CITY OF ALBUQUERQUE

December 9, 2025

**Re: Capra Bank/PHASE1
5171 Lang Ave NE
30-Day Temporary Certificate of Occupancy
Transportation Development Final Inspection
Engineer's Stamp dated 09-19-25 (D17-D106D)
Certification dated 12-05-2025
TRANS-2025-00349**

TRAFFIC CIRCULATION PLAN - PHASE 1
TCL-3

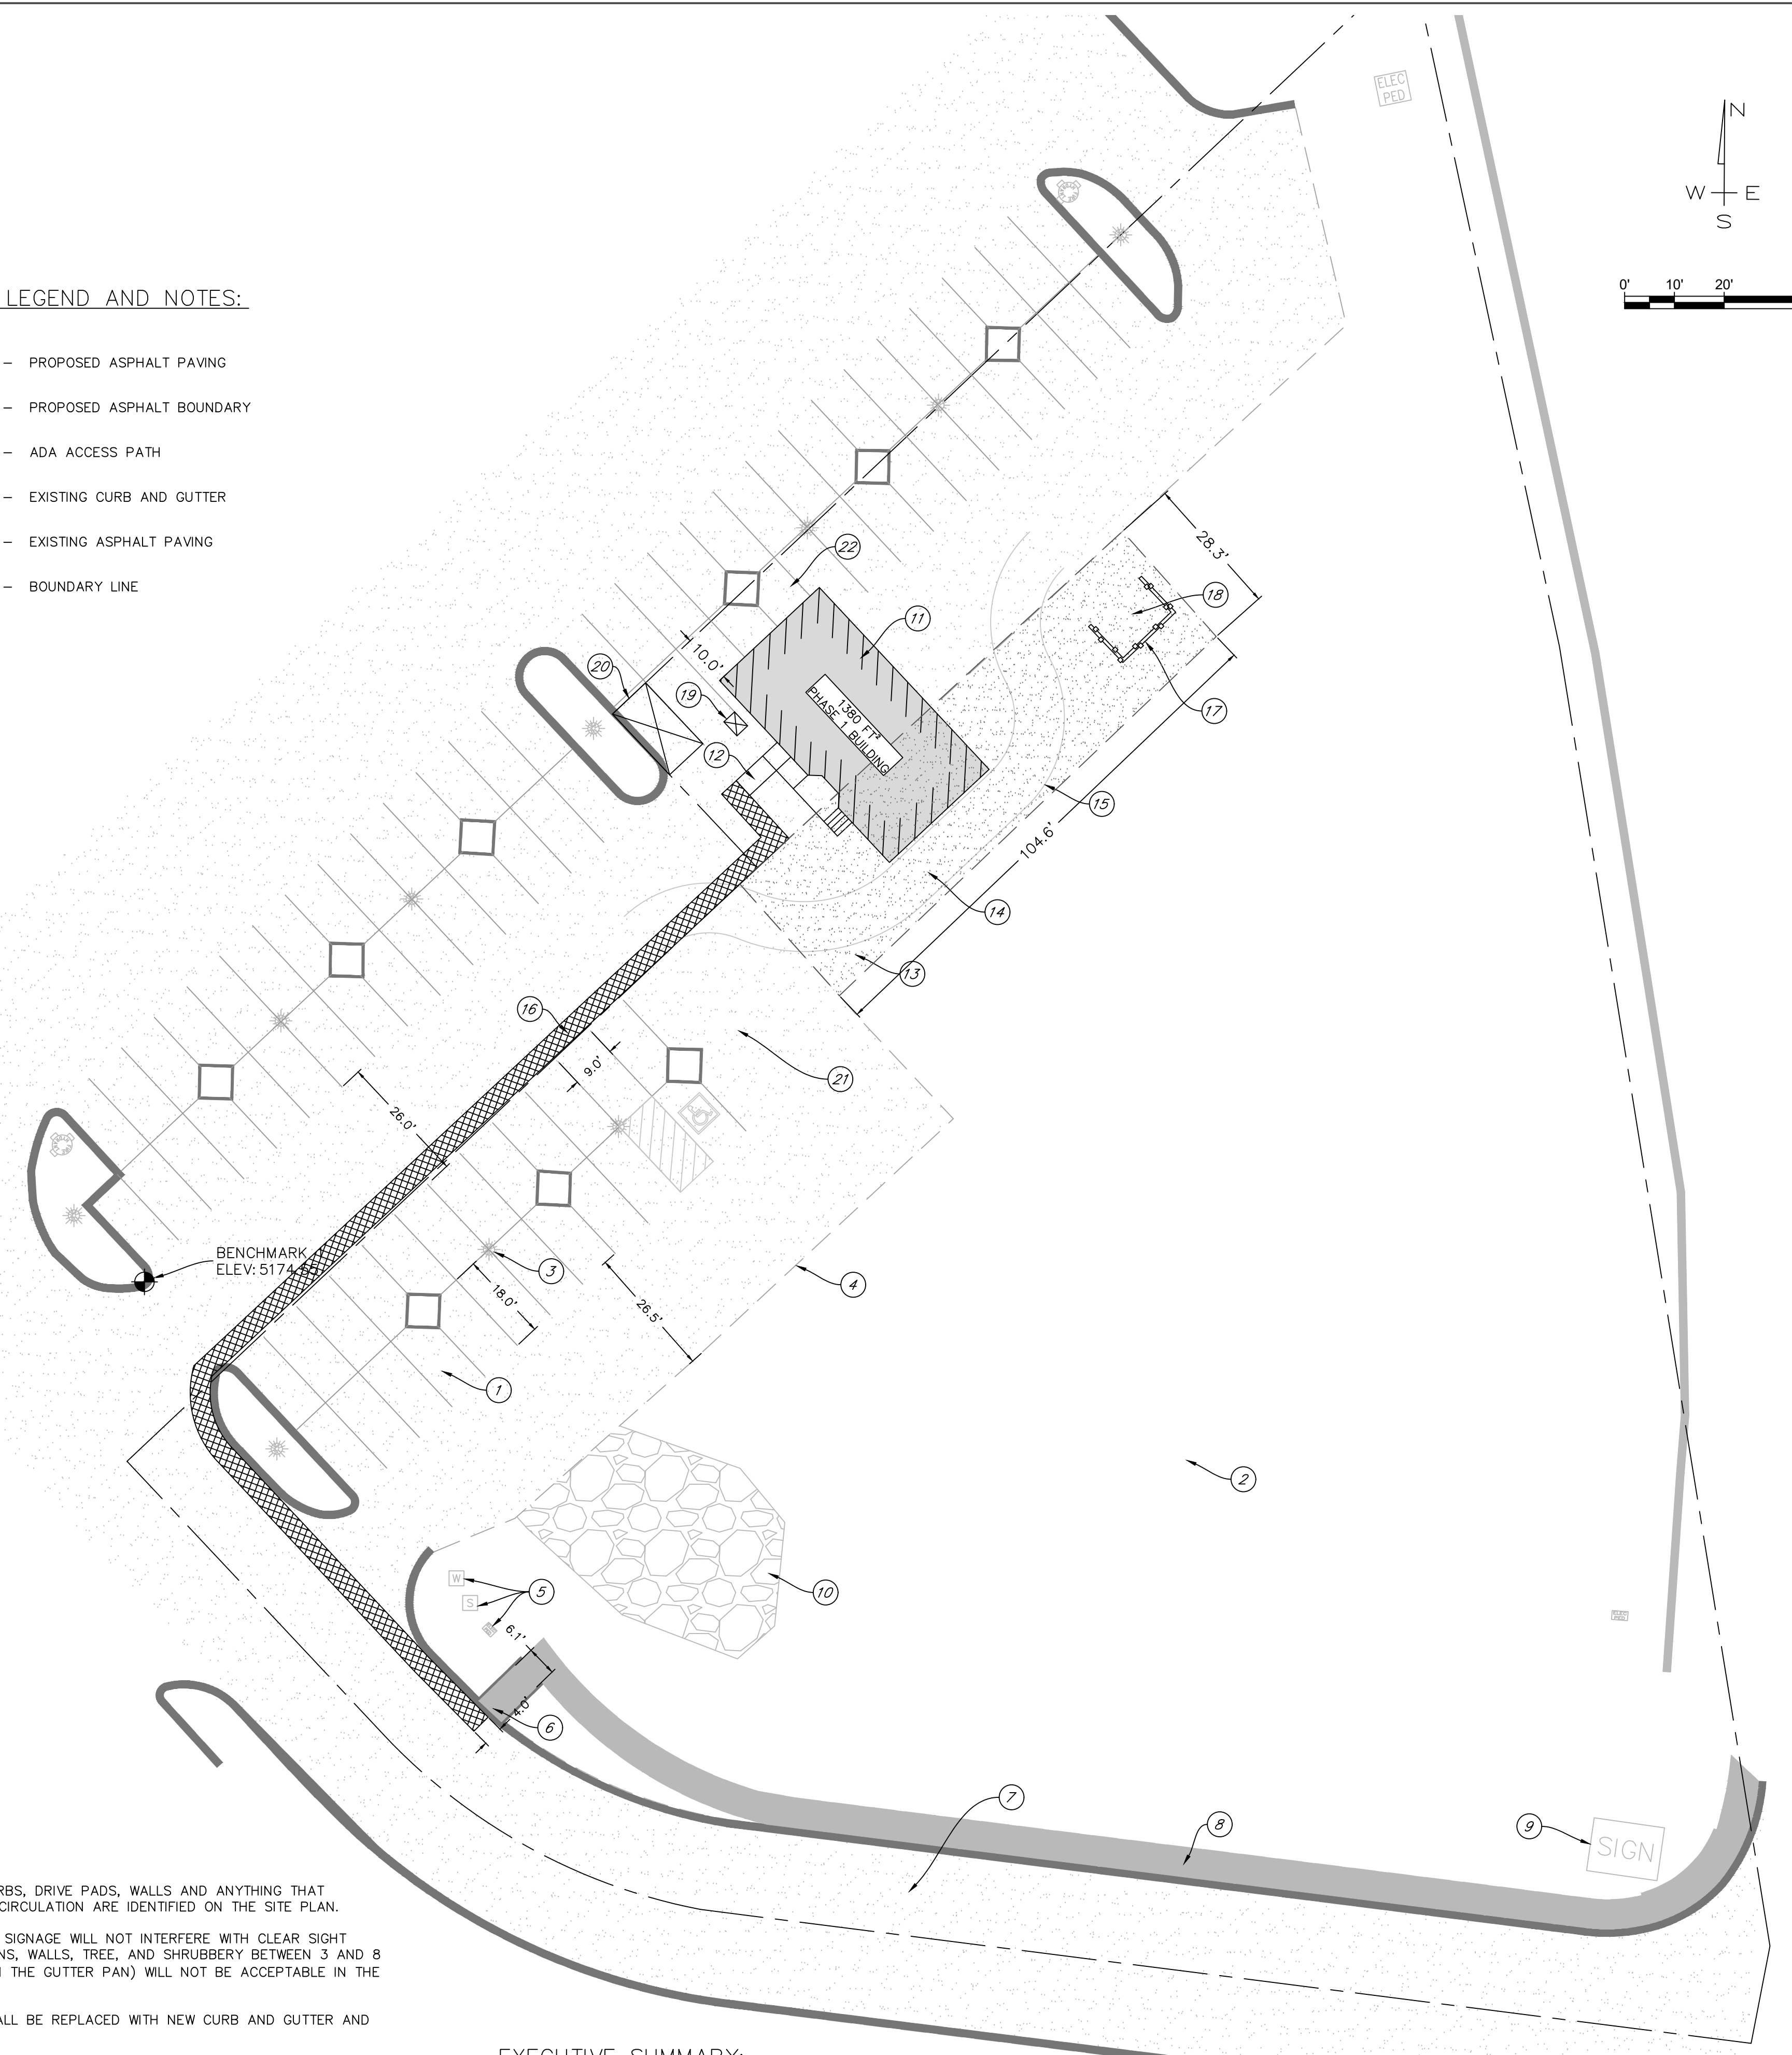
- Keynote 16: per the City requirements and the approved site plan, the 6 ft wide ADA pathway from the public sidewalk to the building entrance must be provided.

Once this correction is complete, email pictures to malnajjar@cabq.gov for release of Final CO.
